STATEMENT OF ENVIRONMENTAL EFFECTS: SECTION 75W APPLICATION, MODIFICATION TO MAJOR PROJECT MP NO.10_0158 (BUILDINGS 7 & 8), MOD 5 – 61 MOBBS LANE, EPPING

Pursuant to Section 75W (1) (a) of the Environmental Planning and Assessment Act 1979, a 'modification of approval is sought to vary Condition No. A2 – Development in Accordance with Plans and Documentation, pertaining to Major Project MP No. 10_0158 (Buildings 7 & 8), as approved on the 12 July 2011.

This modification is to correct an error on Plan No. A011, Integrated Car Park Plans pertaining to the location of the car park entrance and address some minor internal layout issues.

Sheet No. 22 of 28

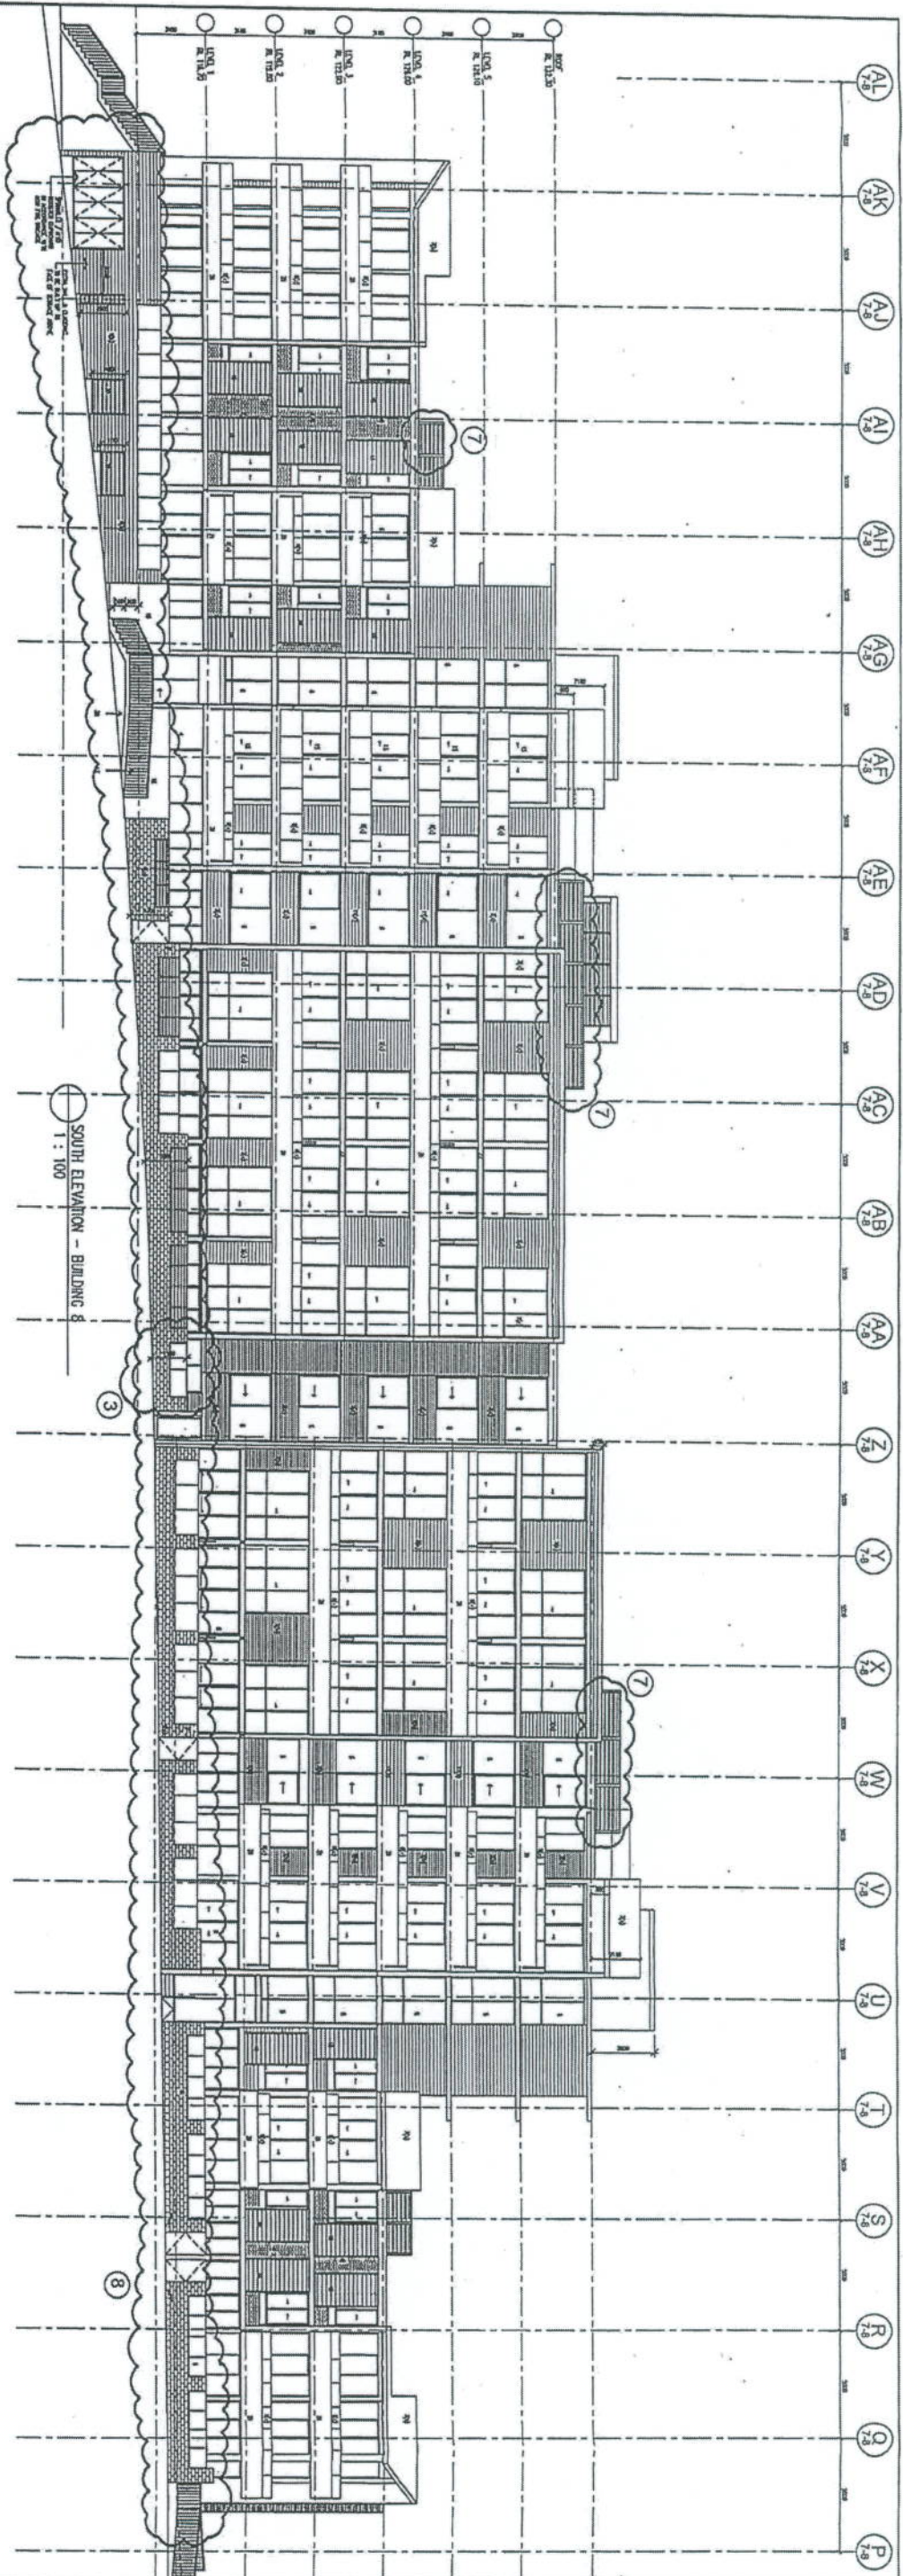
On the 12 March 2012, MP10_0158 MOD 2 was approved for a number of design changes including an elevation view of the car park entrance which is indicated on the northern side of the west elevation. Refer to **Annexure 2**.

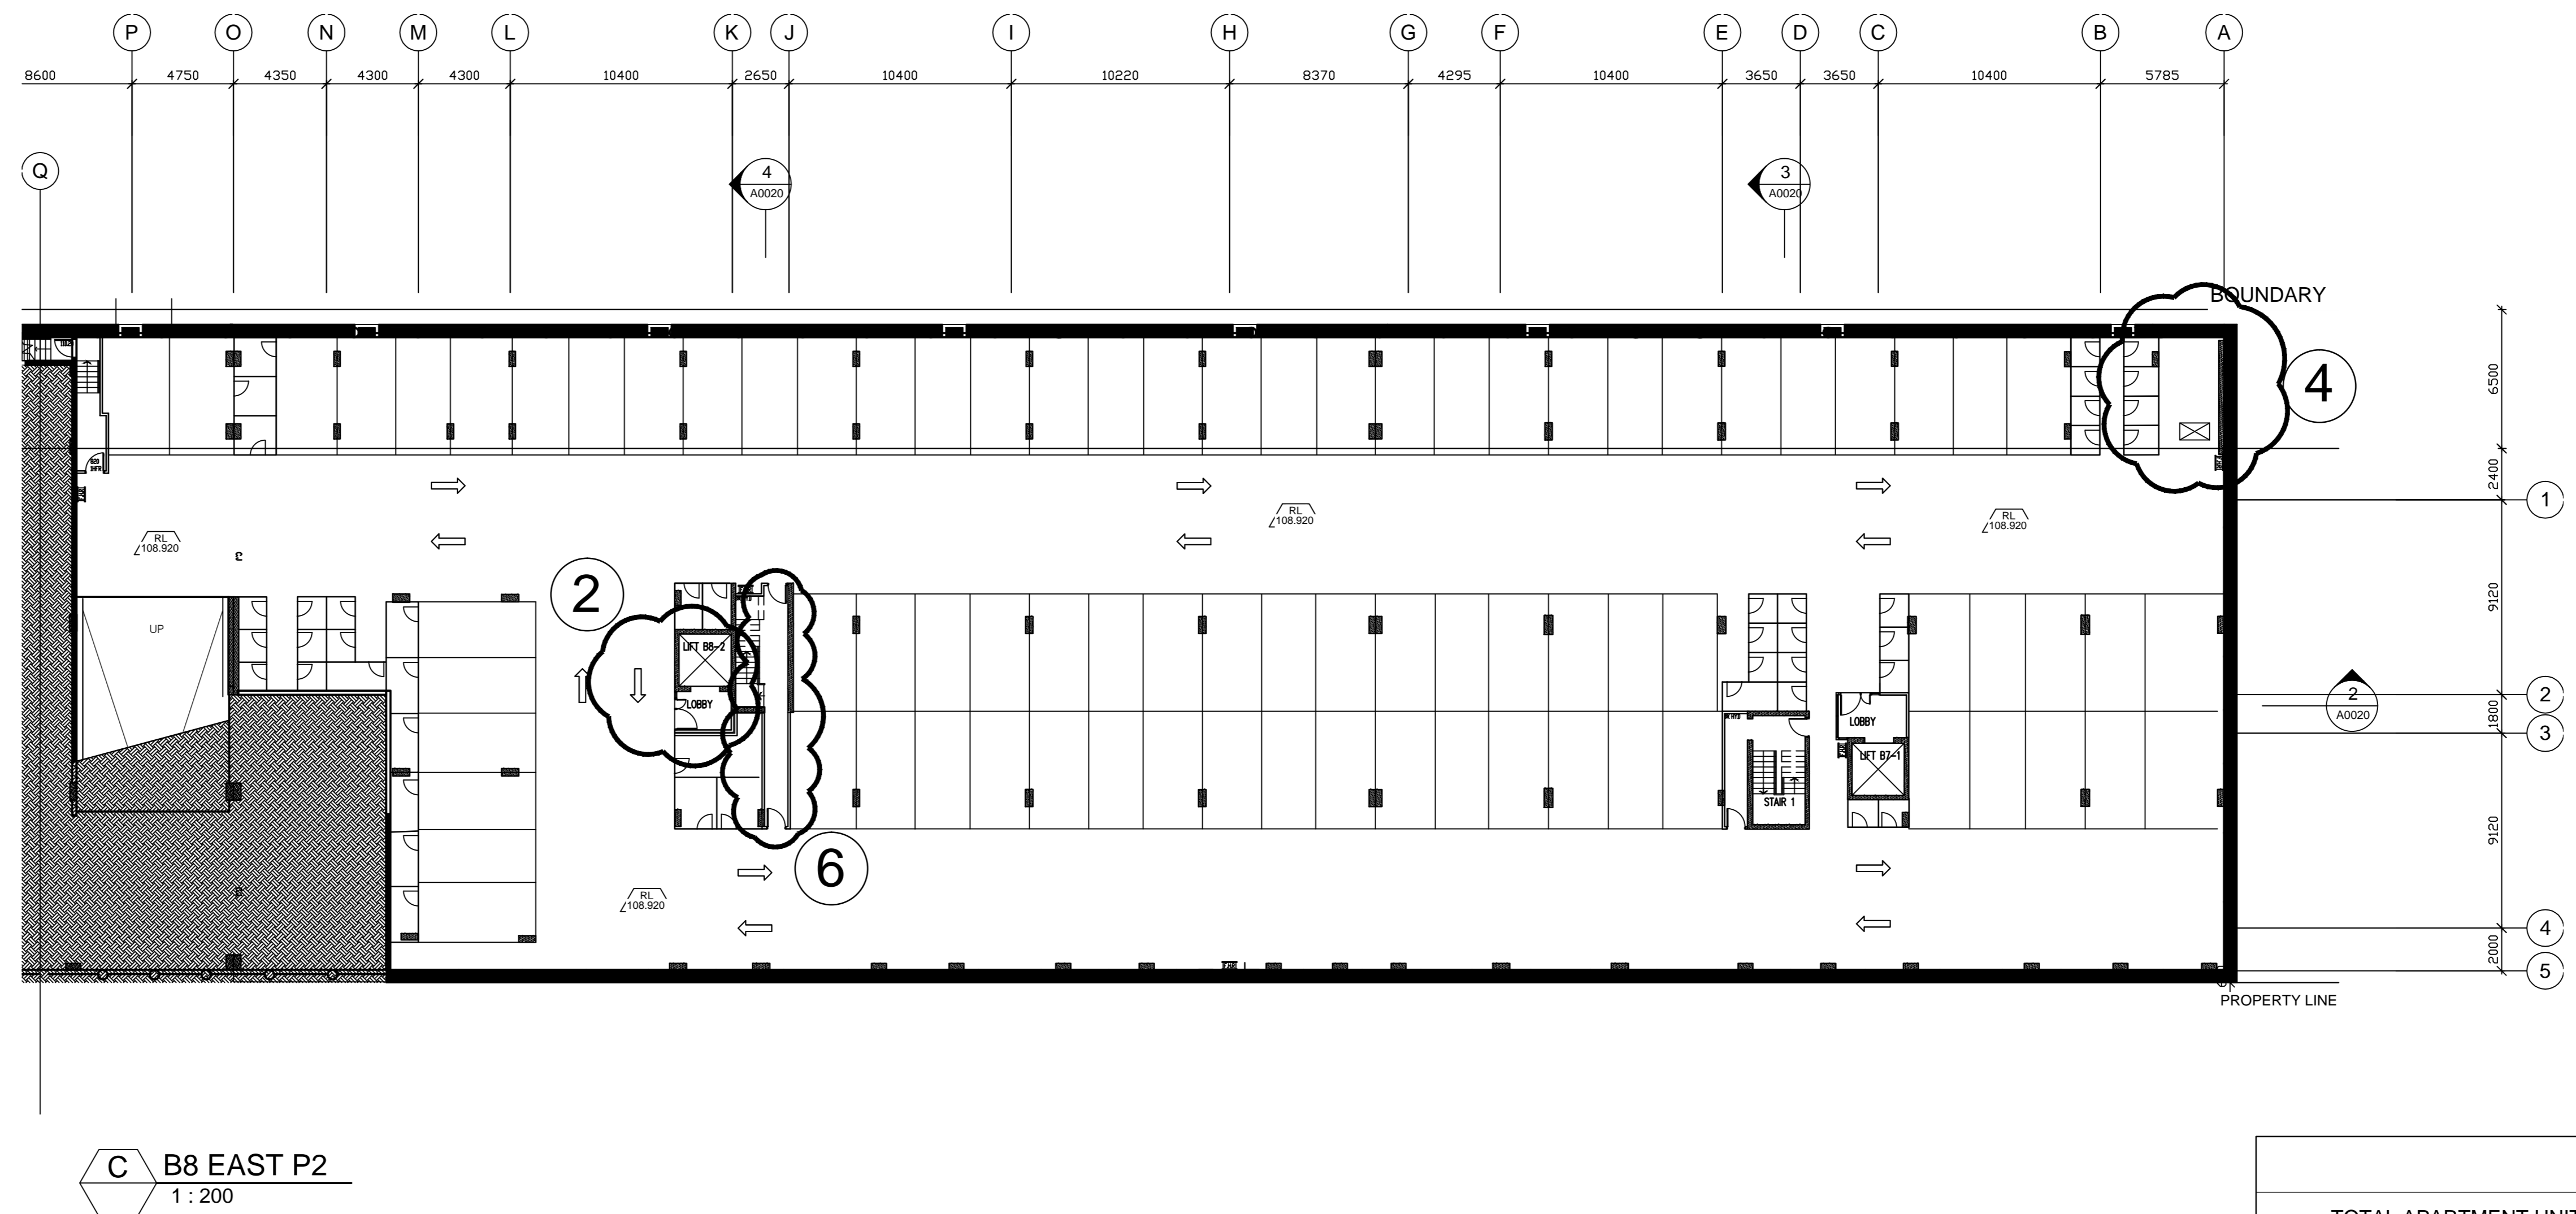
- Relocate the entrance of the car park entrance from the south of the western elevation to the north of the western elevation. (Refer to Note 1 on plan);
- A number of the internal lobbies have been altered (Refer to Note 2 on plan);
- 1 plant room has been added (Refer to Note 3 on plan);
- A plant room added and fire stairs have been removed, as not required by BCA (Refer to Note 4 on plan);
- The garbage room has been re-configured and a managers store room added (Refer to Note 5 on plan);
- Fire stair passage extended for BCA compliance (Refer to Note 6 on plan);
- 1 plant room removed (Refer to Note 7 on plan).

Further it should be noted that all car parking spaces and storage have been altered to suit structural co-ordination of the car park.

It is recommended that Condition A2 be amended that Drawing A0011A be deleted and replaced with A0011B as follows:

Architectural Drawings prepared PTW Architects			
Drawing No.	Revision	Name of Plans	Date
A0011A	A	Integrated Car Park Plans	21.10.2012
Architectural Drawings prepared PTW Architects			
Drawing No.	Revision	Name of Plans	Date
A0011B	B	Integrated Car Park Plans	20.11.2012
